Date 6 October 2023  
Our Ref 23/01165/FLH

**Town and Country Planning Act 1990 (As Amended)**  
**7 The Grove, Epsom, Surrey**  
**New additional vehicular access and alterations to landscaping of front garden**

Thank you for your planning application which was received on 25 September 2023. We have checked the application and have found that it is invalid. This means that we cannot currently accept it for registration. The following details must therefore be submitted for the application to be registered:

Proposed Plan

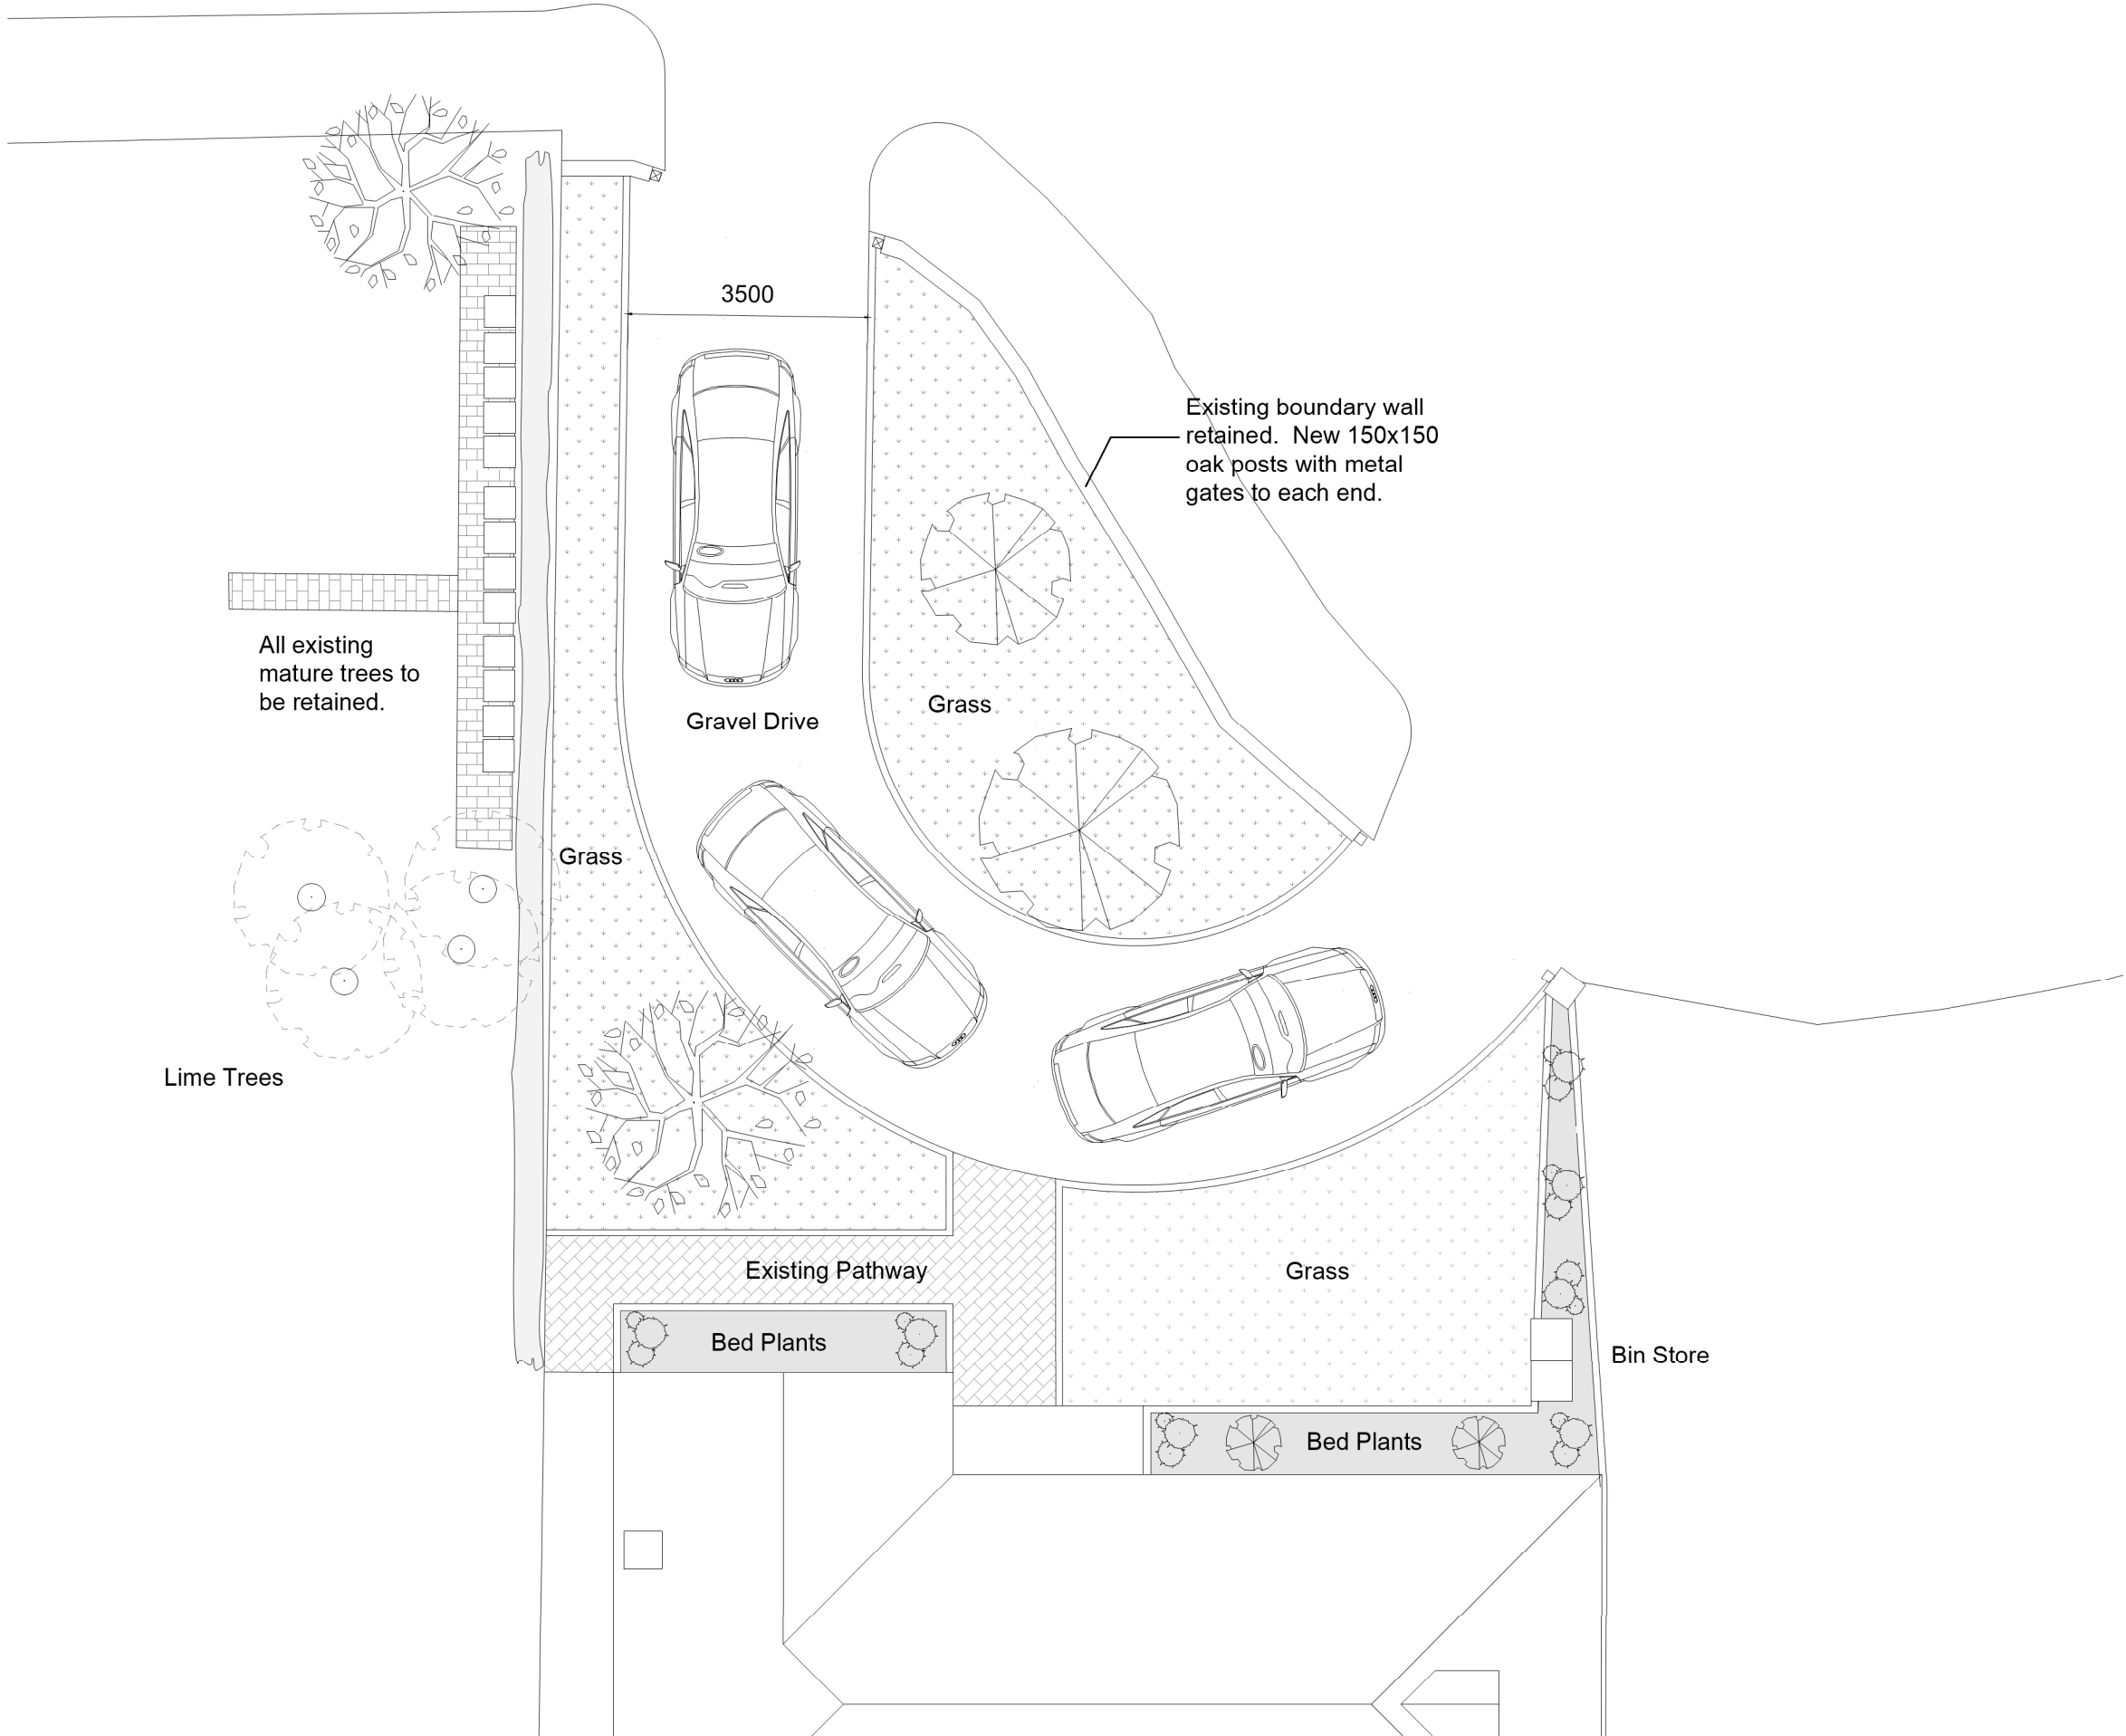
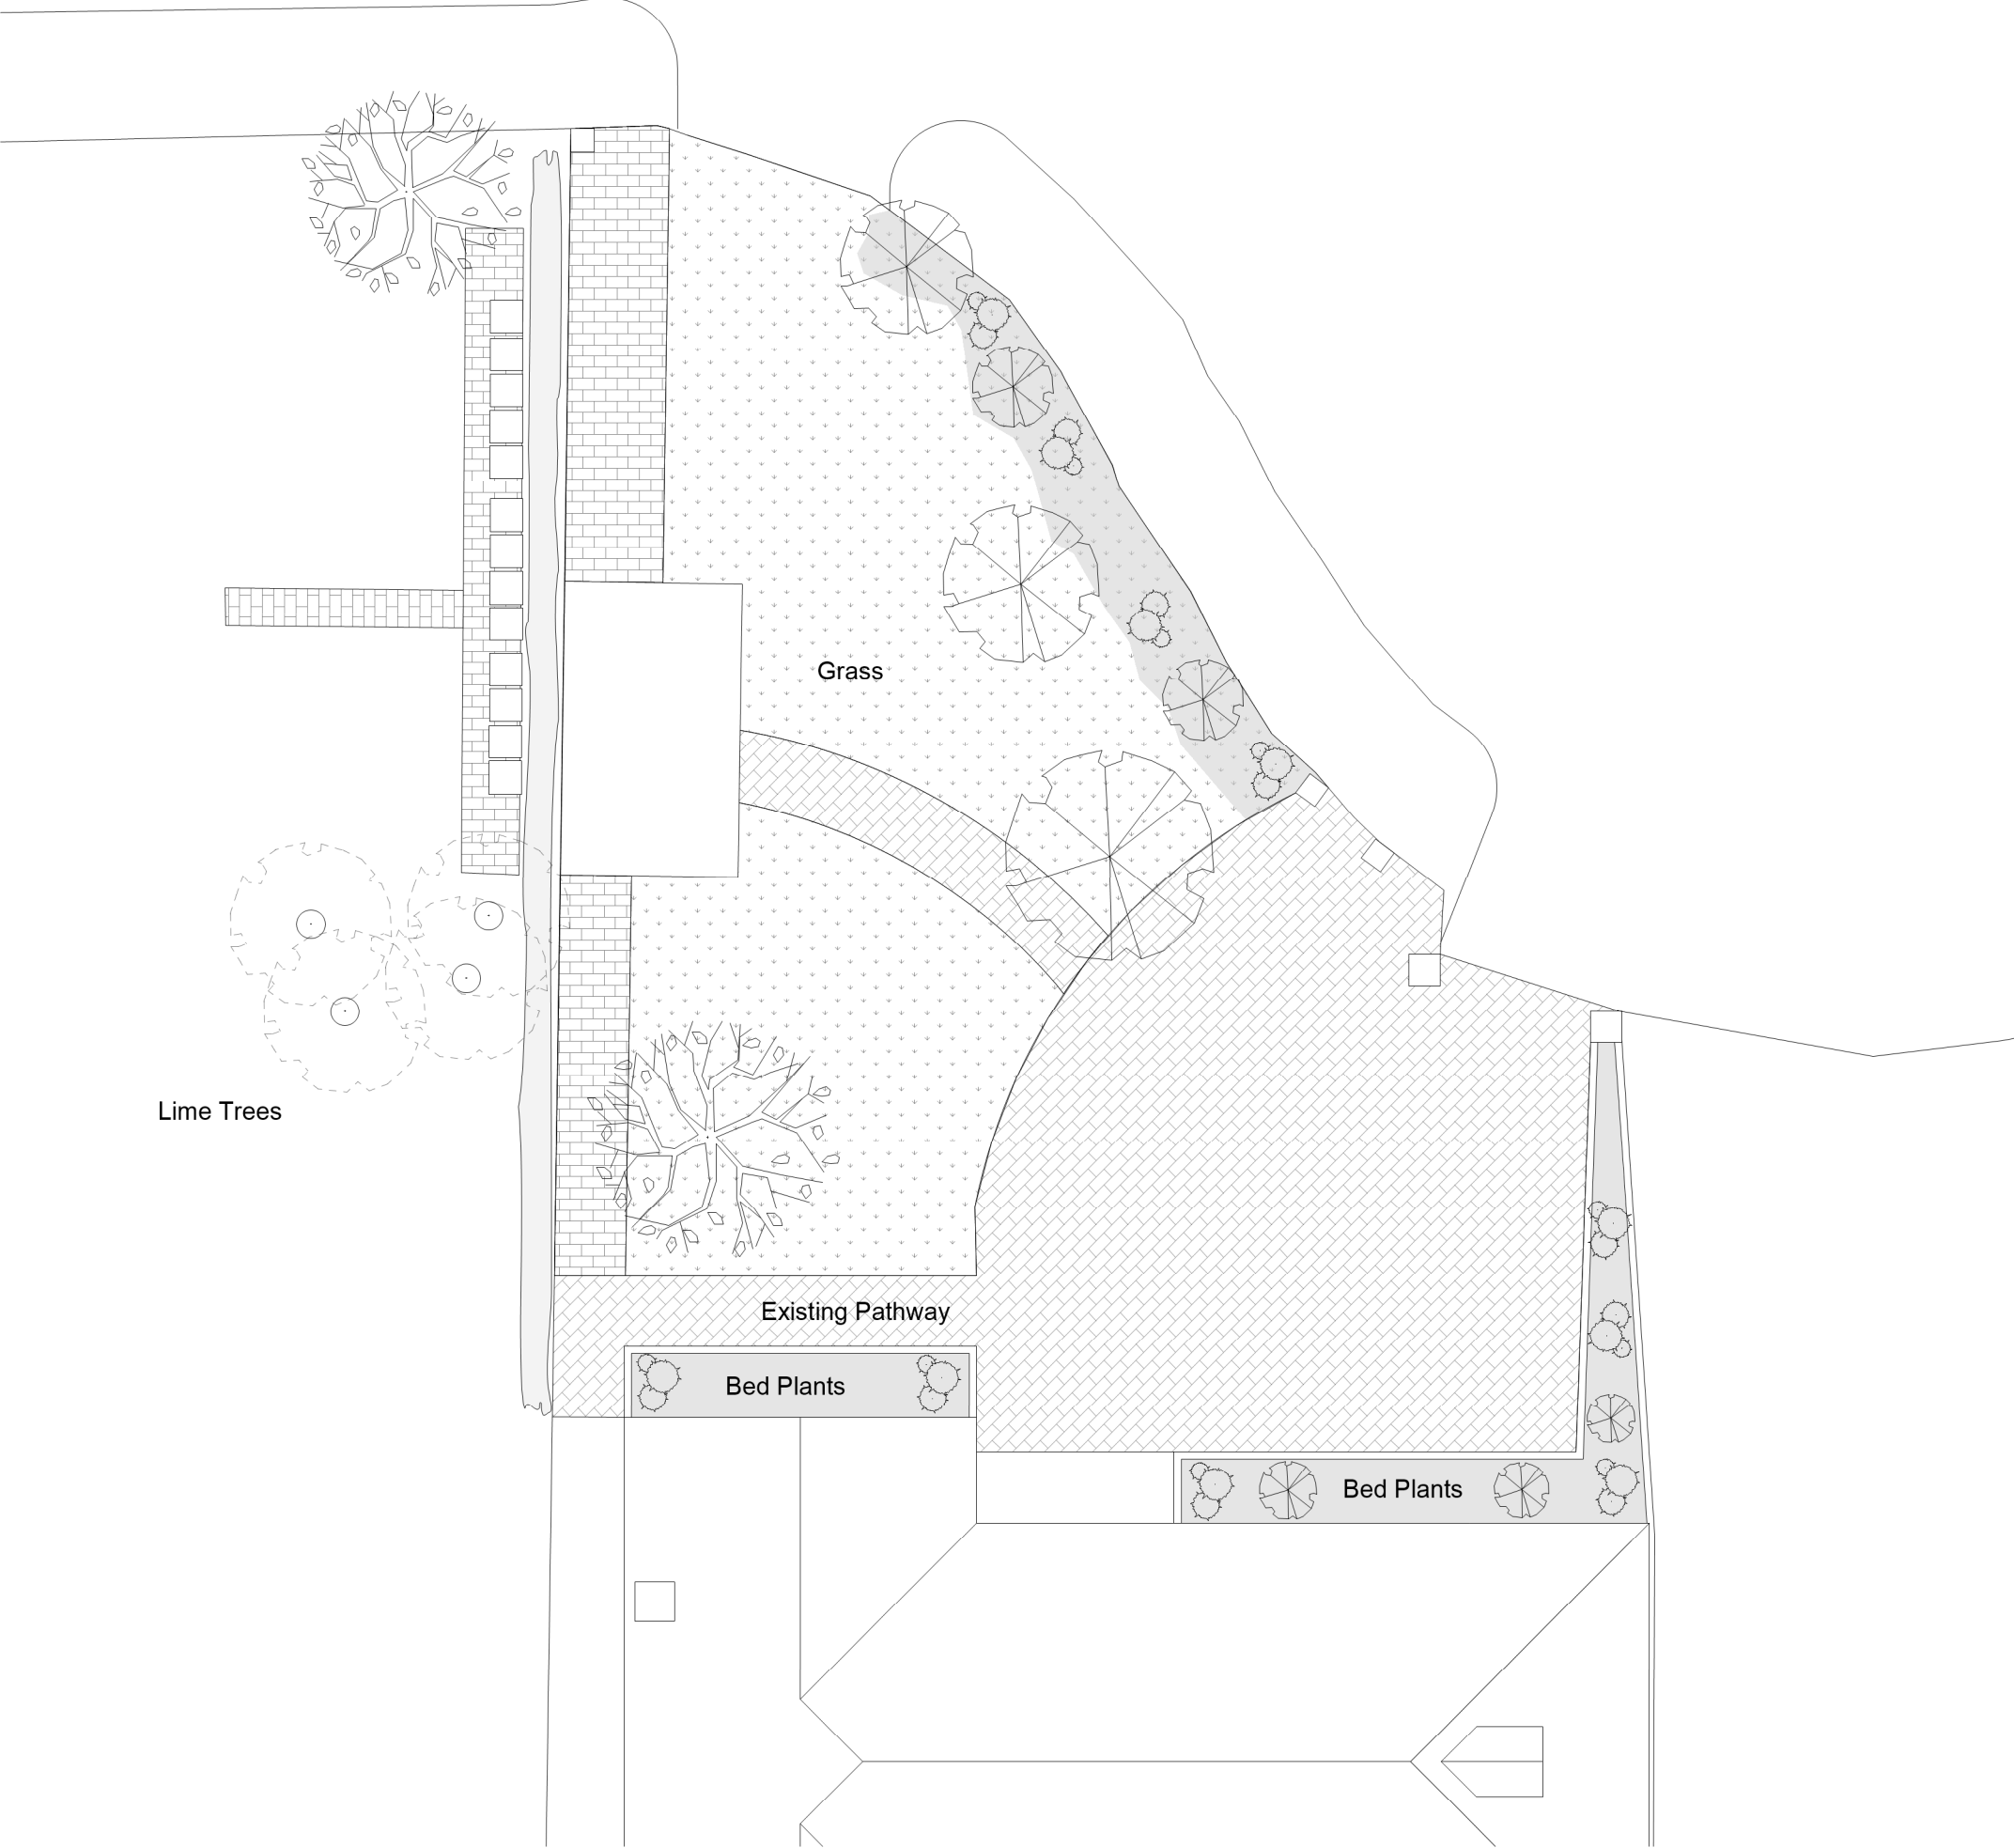
4 Please submit an existing and a proposed Site Plan at a scale of 1:200 or 1:500 showing the proposal clearly differentiating from the existing (e.g. hatched) and its relation to the site boundaries, any other existing buildings on site and the neighbouring properties. The existing site plan is to show the current situation and the proposed plan is to show the proposed situation. Please ensure the plans extend to the highway to include the new and existing vehicular access.
